CITY OF PORTLAND, MAINE
DEVELOPMENT REVIEW APPLICATION
PLANNING DEPARTMENT PROCESSING FORM
DRC Copy

2010-0031
Application I. D. Number
9/14/2010
Application Date
New Single Family
Project Name/Description

Shukria Wiar - 67 Douglass Street Single Family application

From: Shukria Wiar
To: NYR4ever@maine.rr.com
Date: 10/13/2010 1:27 PM
Subject: 67 Douglass Street Single Family application

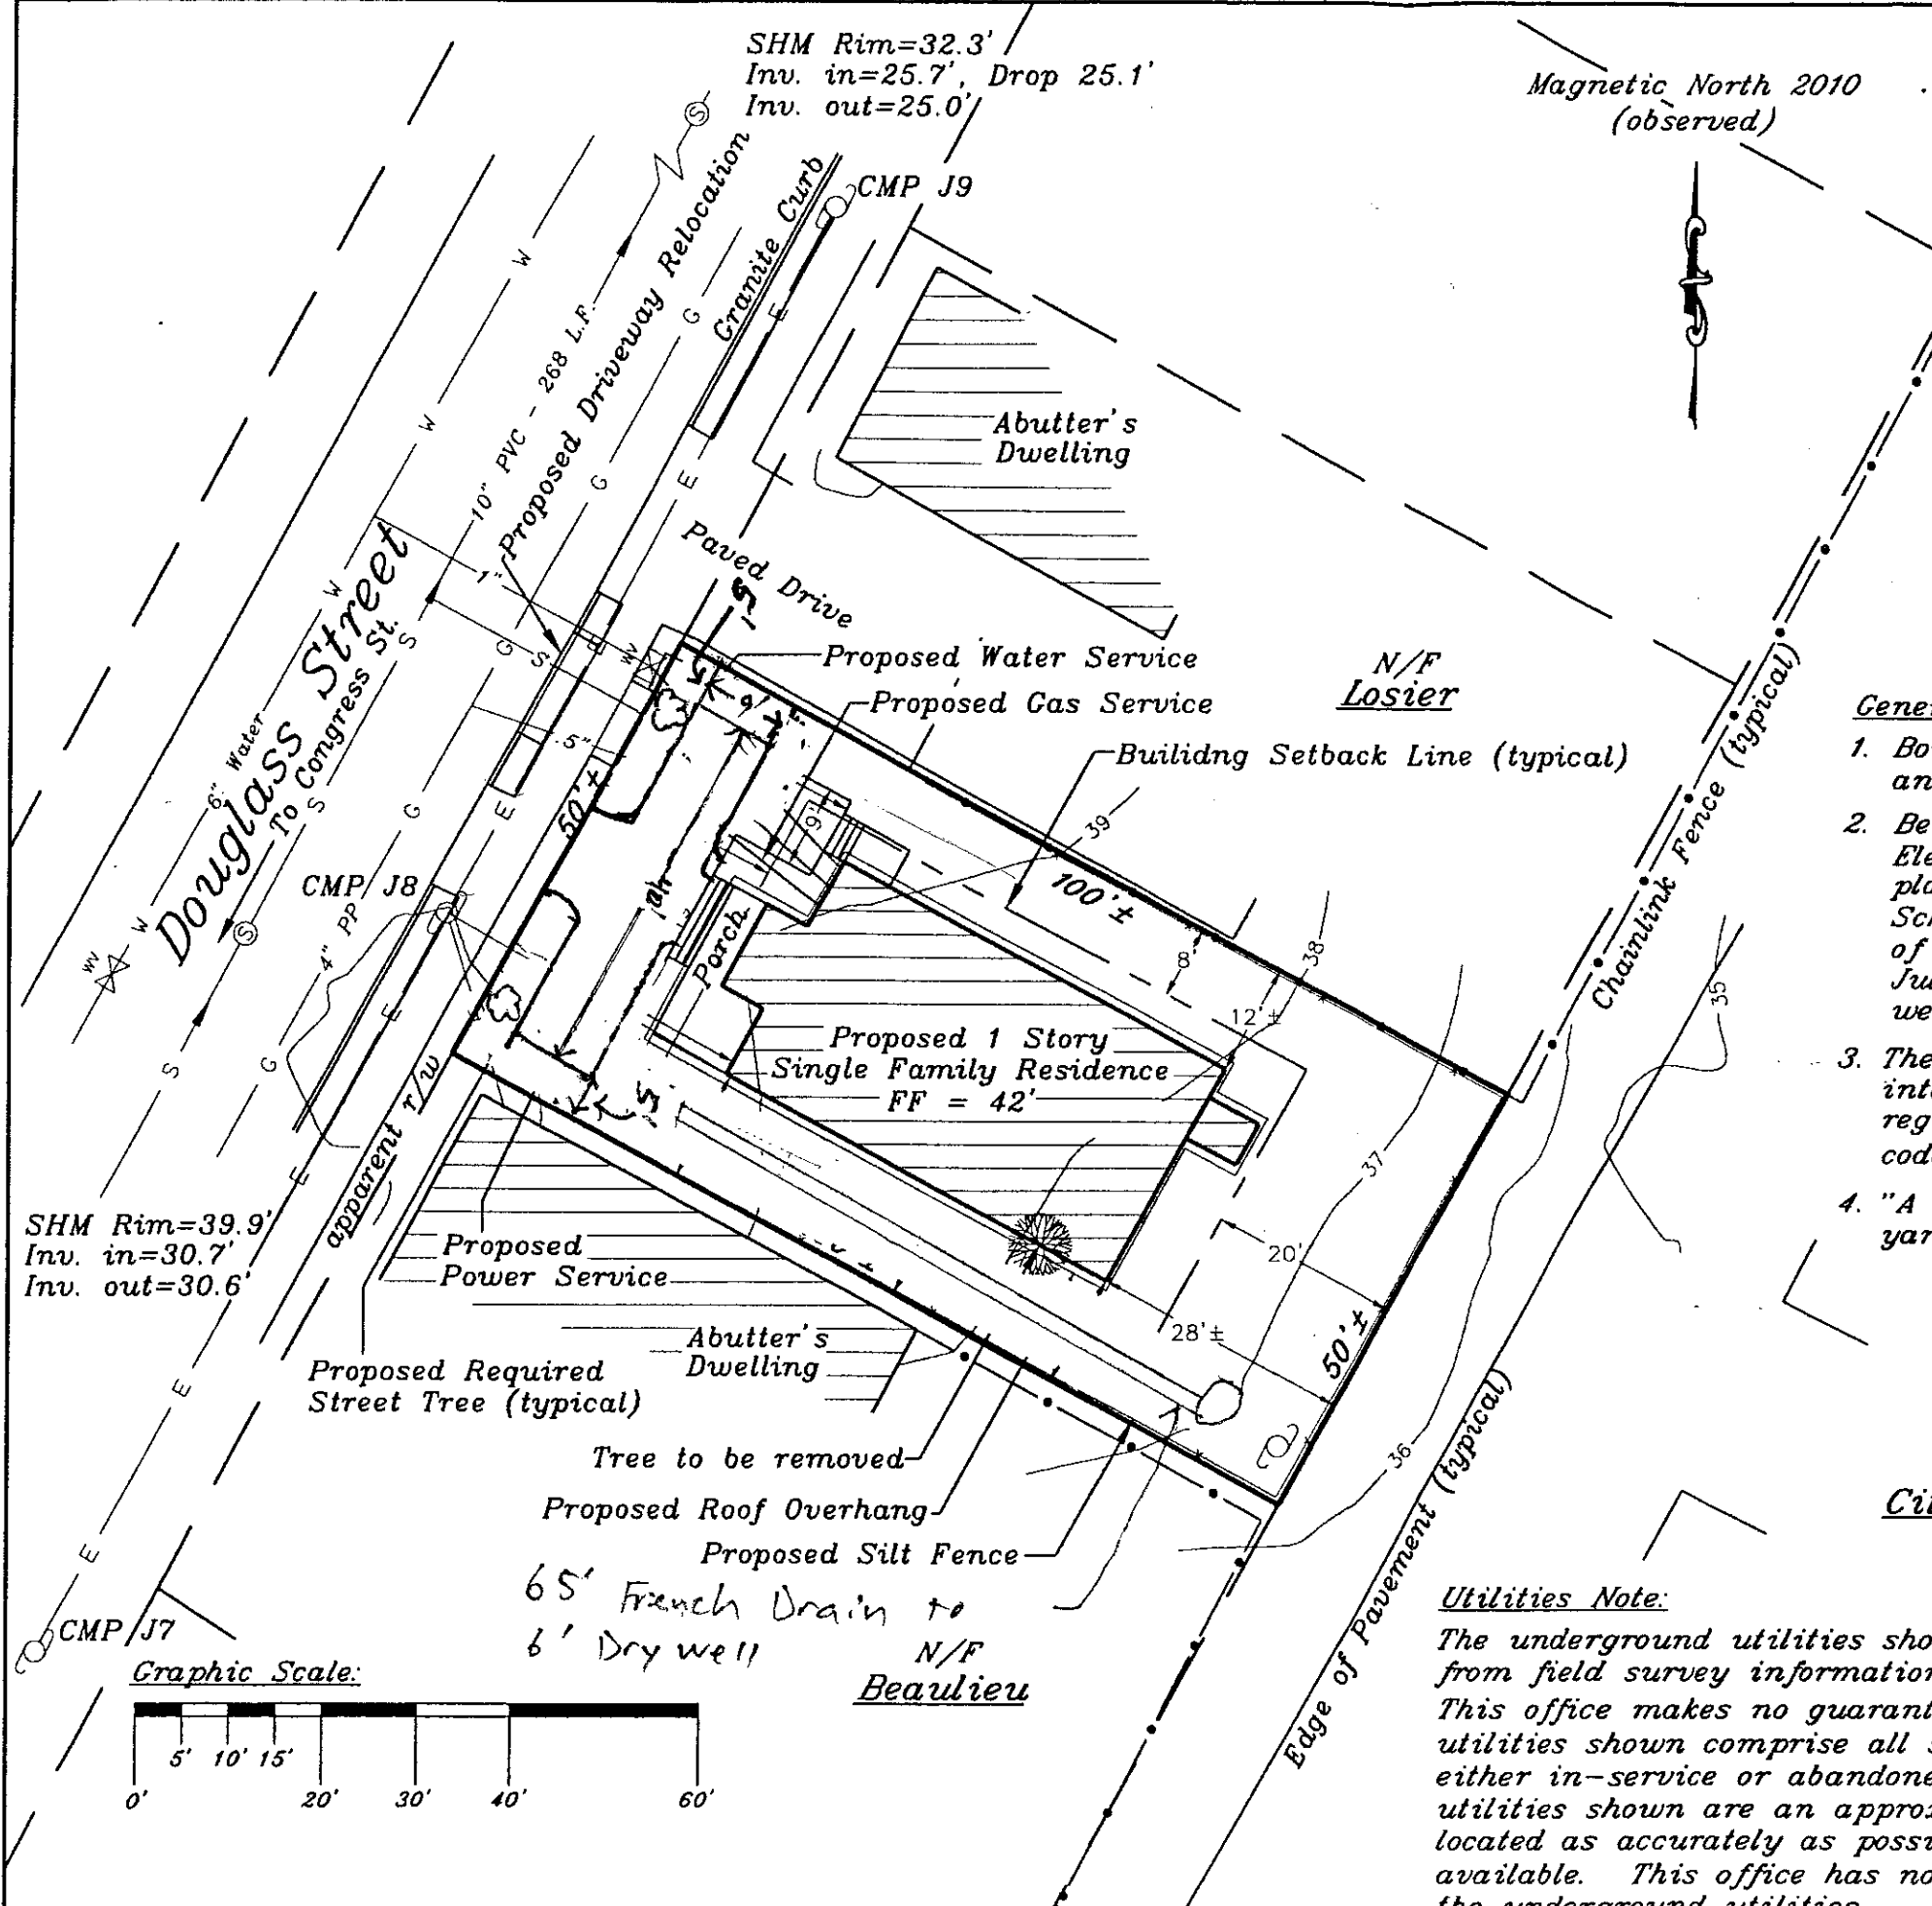
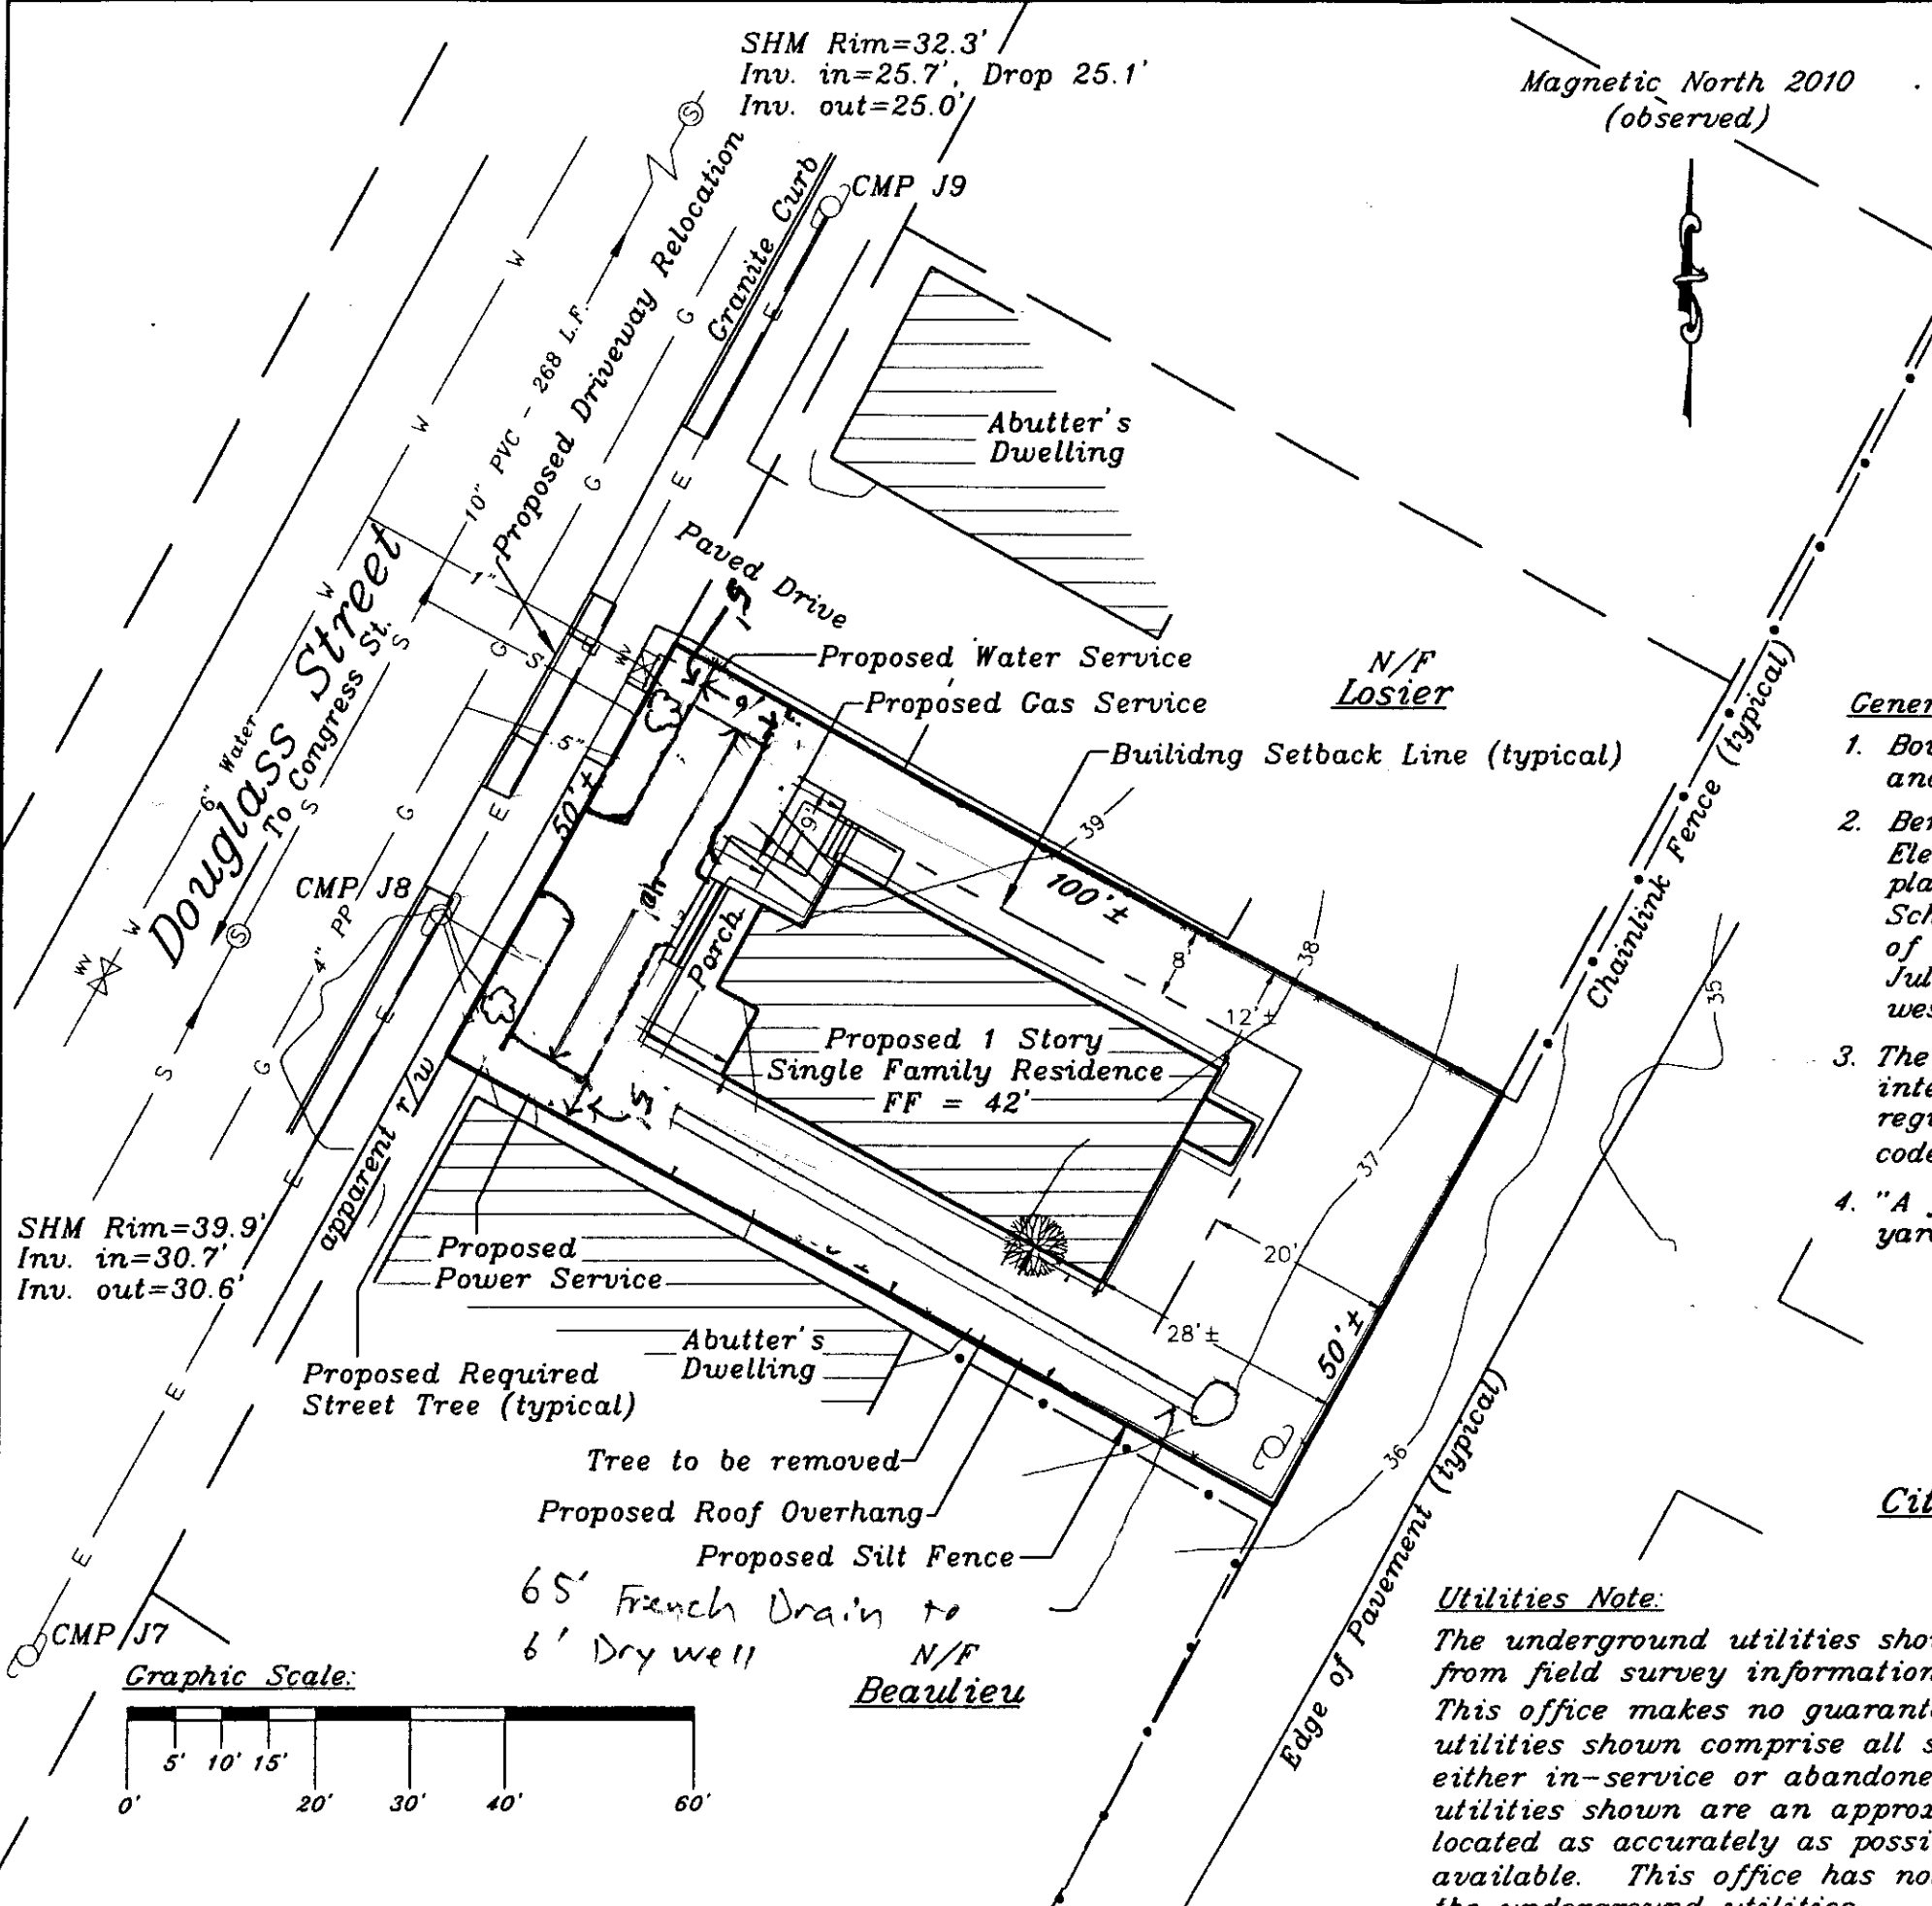
1. A boundary survey must be submitted for a review; the survey must include the following standards:

2. As proposed stormwater seems to drain onto the school property; the city does not have issues with the back portion of the property draining into the school property but requires the front portion of the parcel drain into the street. Please revise site plan to show this requirement.

- 01 The site shall be graded as such that the front portion of the parcel shall drain to Douglass Street and the back of the parcel shall drain to the City's property.
